Hearing Transcript

Project:	A46 Newark Bypass
Hearing:	Issue Specific Hearing 4 (ISH4) - Session 2
Date:	05 December 2024

Photomontage 25: Year 15 in operation (planar projection, field of view 39.6 degrees x 27 degrees, to be viewed at A3)

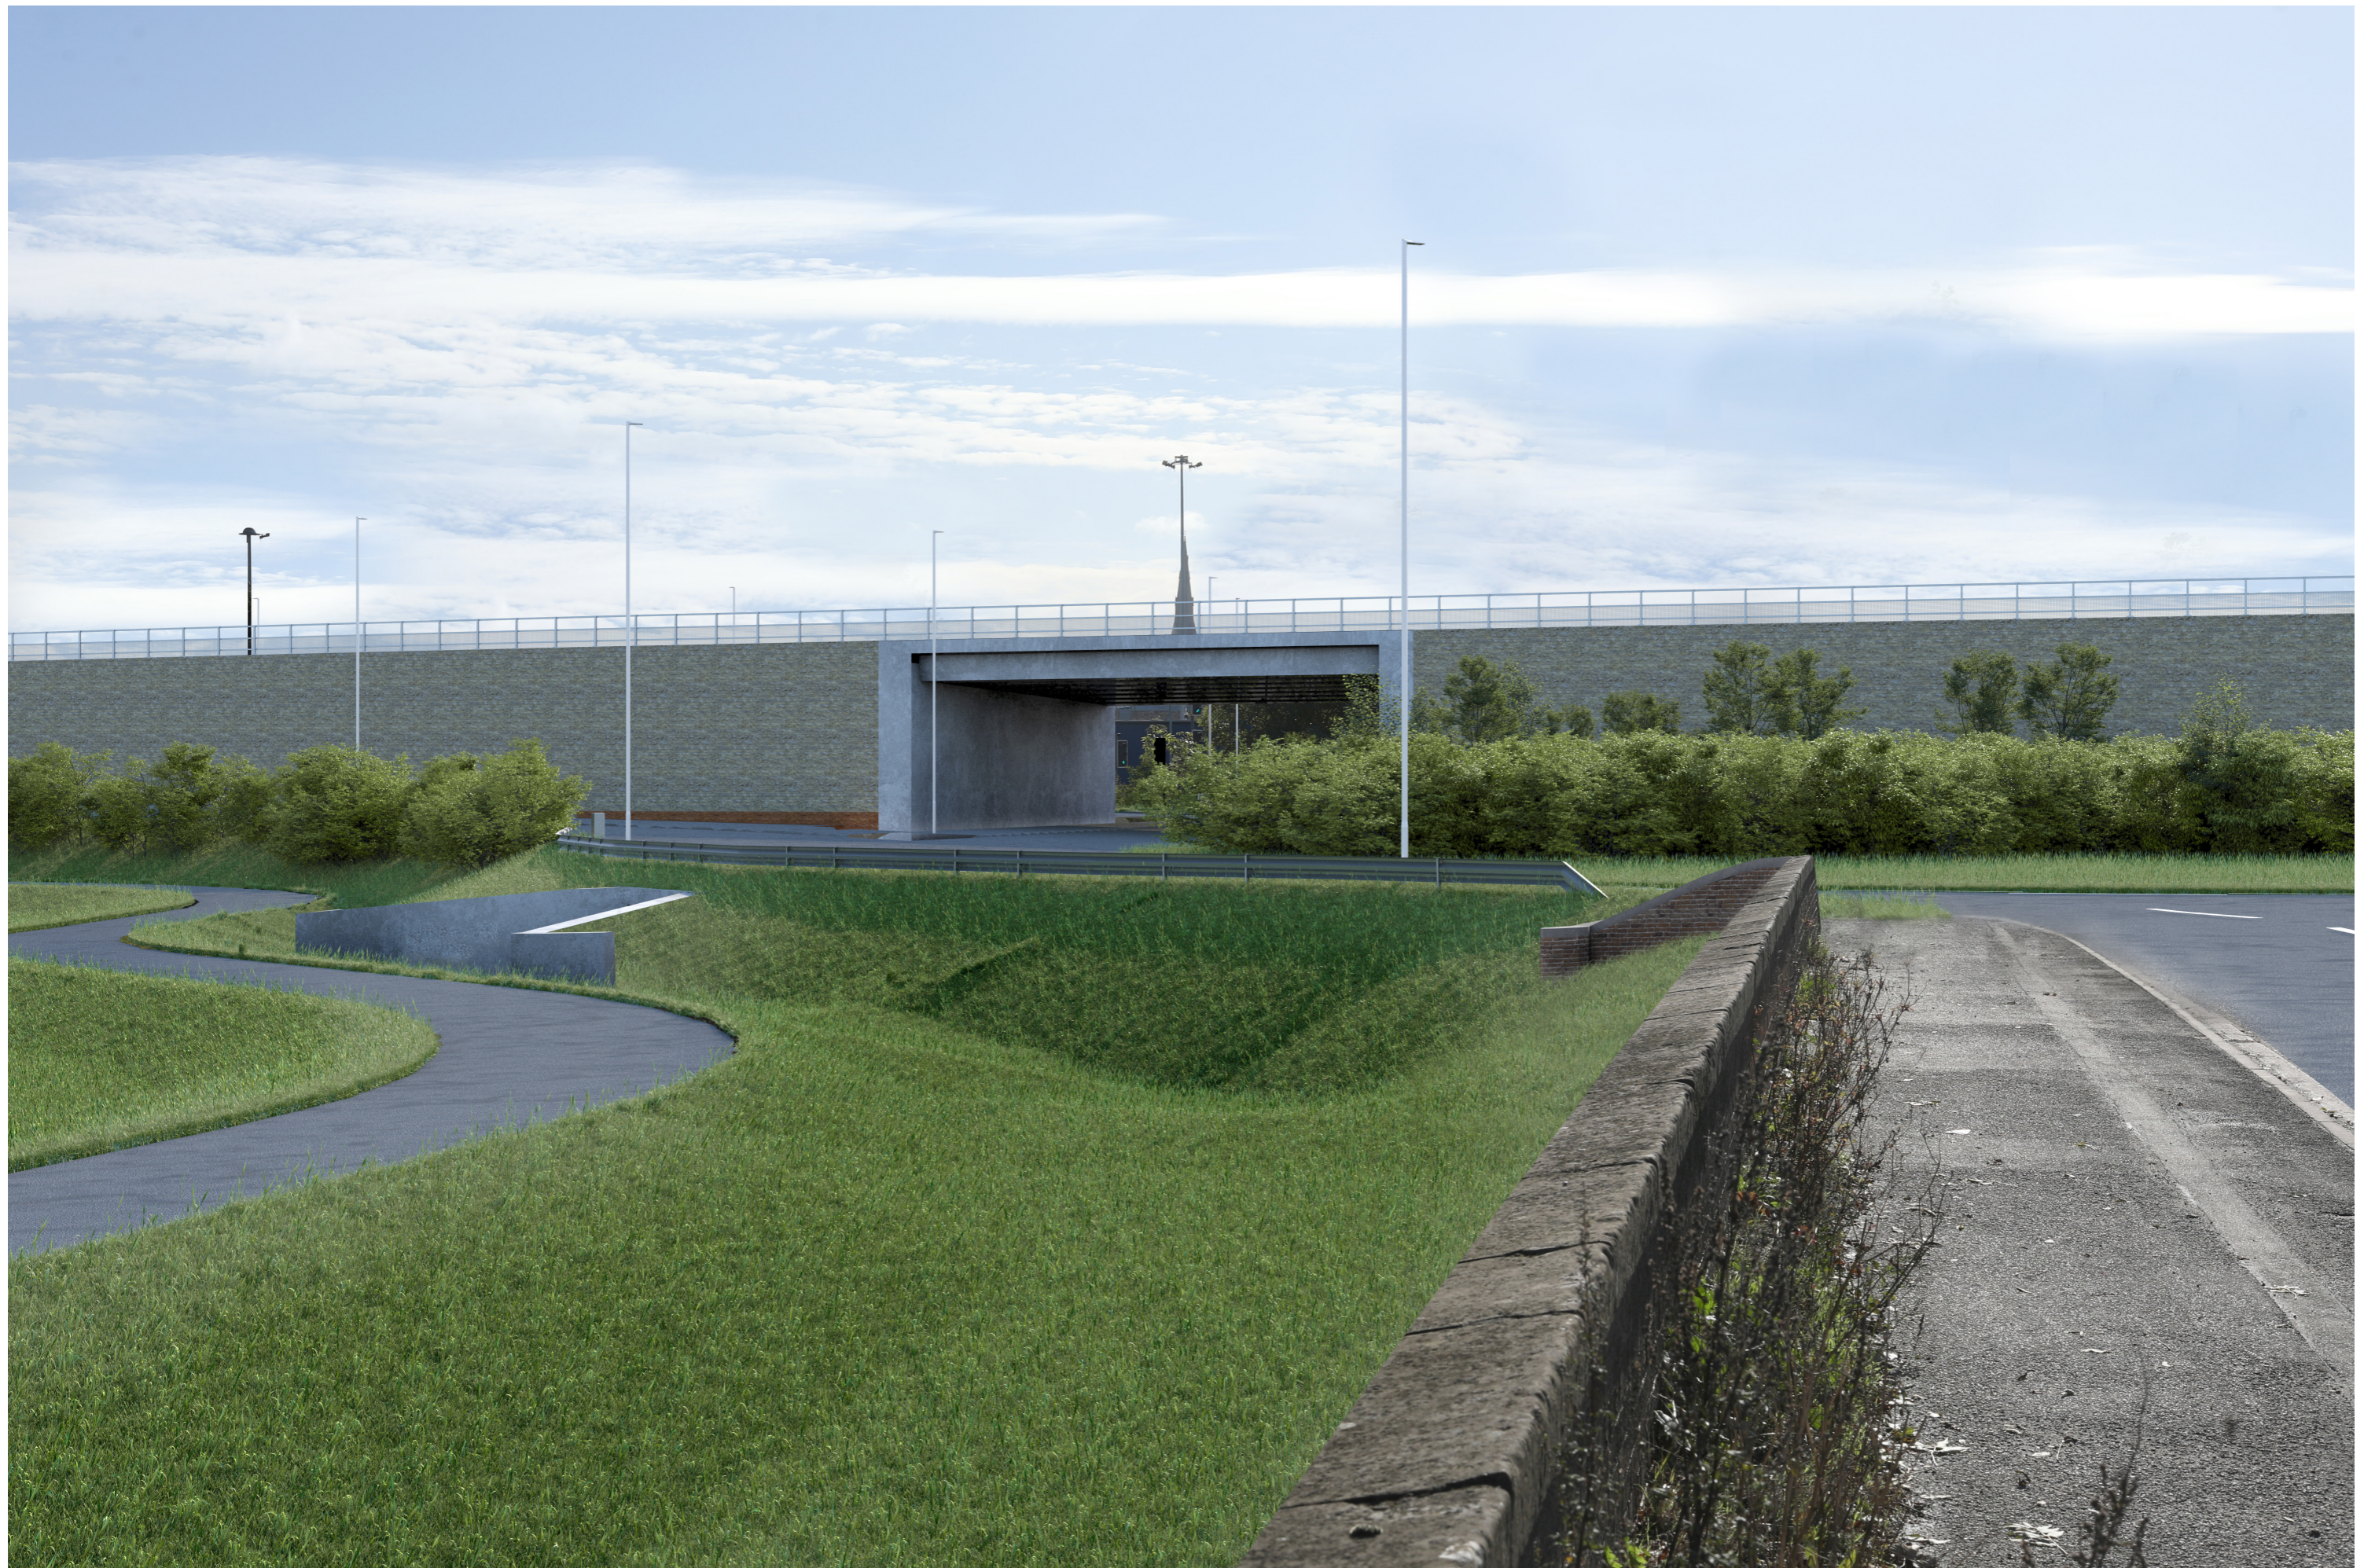
and rep two, five and 020, but both are relevant in terms of the impact they're going To view point 25 the existing situation shows vegetation as you're approaching on the A 616, towards Newark, south east, with existing vegetation on both sides of the road, framing the view down to the upgrade existing junction, and looking at year one that vegetation has been removed. So you see this full expanse of the grade separated junction and retaining wall with the framing vegetation having been removed at year

25 there's not a huge difference in terms of vegetation either side of the A, 616, and still this same horizontal expanse of the retaining wall and the elevated structure.

Alison Stewart for Newark, and show a district council it is. It relates to the loss of the boundary vegetation either side of the A, 616, as you're approaching Newark, you've got the new elevated carriageway along the full view, and because we've lost the framing vegetation that was there on the existing situation, it's a much more open view, and our concerns are that there is no proposals at the moment for any planting in that area. And was just wondering why there wasn't more thought to how this could be mitigated against this impact of this new structure on the approach into Newark.

yes, I think obviously we are raising concerns of those views into the town and out of the town. And I think that certainly views into the town could be kind of softened with a lighter structure, and we feel that it hasn't really been justified or kind of reasoned out why this is the design that's been put in front of us today, and why other options that perhaps are lighter weight haven't been brought forward to this stage.

Clay, you've done for the applicant? I think it's worth noting, when looking at this photo montage that actually there's an a line of existing vegetation that will be retained, which is immediately, essentially behind the photographer in this location. And therefore anything north of this we feel still will allow the containment of roadside views in a similar way to as it currently does, albeit understanding where there are breaks in that existing vegetation, then oblique views may be afforded across the surrounding landscape to the a 46 and the grade separated junction,

Yes. So, as we noted earlier, the swells in this location have a highways drainage function. The reason we have chosen them is for the aspects around nature based solutions, moving away from kind of the historic hard features that we might see to enable co benefits in terms of biodiversity and landscape integration. We've made an allowance for, I appreciate those can't see the environmental master plan currently, but we have made an allowance for individual trees and, again, some shrub planting adjacent to the retaining walls as you head left around the junction. In addition to that, we've also obviously got the planting on the junction itself. In the image that we looked at in year one, see they're very small in that location at that time. However, by year 15, they will have established to aid the screening of the junction, particularly at the lower levels, where the lower band of the retaining structure would be screened by that intervening vegetation, with the individual trees creating a greater aspect of height, which, in turn, can help break up the upper, upper sections of that wall. Okay,

Claire Eden for the applicant. So as a I think this is a general rule that we can talk about across the scheme. And our approach is that we've sought to maximize the retention of existing vegetation where we can and also maximize the planting, as you'll see on this on the screen here, we do have a number of constraints associated with the with the drainage of the of the scheme, but in doing so, have chosen this solution because we feel that it gives a more naturalistic approach to draining the scheme,

as opposed to hard features. We have produced some patrose, some planting along that boundary, albeit we do have to be mindful of planting offsets from carriageways in order to align with industry standard guidance around the safe operation of the highway and LD 117, appreciating as well that perhaps the planting that provision that's there already may have naturalized over time and possibly not being maintained as per the highway standards in in respect to offsets from carriageway.

Thank you. John Bose, on behalf of the applicant, I'd already looked at this, and we did look at this as part of the options development, and discussed it with a number of the stakeholders. So in providing an open structure, the spans would become larger, and the overall depth of the structure would increase between 305 100 millimeters, and this would then increase the height of the structure itself, the road alignment, because we couldn't come down at this stage. And it would also reduce the safety of the slip roads, and the mergers and the departures we have there due to the increase in height the land beneath the open structure that would be hardened and wouldn't be able to be planted, creating a utilitarian environment. The area beneath the open structure would be vulnerable to anti social behavior, bitter collection and also arson risk the center of the gyratory, as shown on the existing one year and 15 year plans that would still be planted. So the open aspect would actually disappear over time, because the planting would block that view through the structure, the views of Newark castle and the church spire, in our view, at that time, and we assessed it, were already restricted by the trees and shrubs on the approach to the gyrate tree to the existing roundabout, and that those views actually came into view. And the feeling of an avenue, as I would describe it, is actually beyond the capital market roundabout. As you head down the southern side of Great North Road, in terms of the multi span structure, it would need to be placed on bearings because of its length and due to temperature changes. It allows the bridge to move. These two proposed structures are integral structures and have no bearings. If bearings are provided in a multi span structure, this would provide additional maintenance and repair requirements, increasing health and safety risks of working at height and also removing and replacing the large bearings in the structure. In terms of the final part of the consideration, we looked at the capital and whole life costs the two at the example, of just opening up the center would increase this by 6.5 million pounds. Thank you.
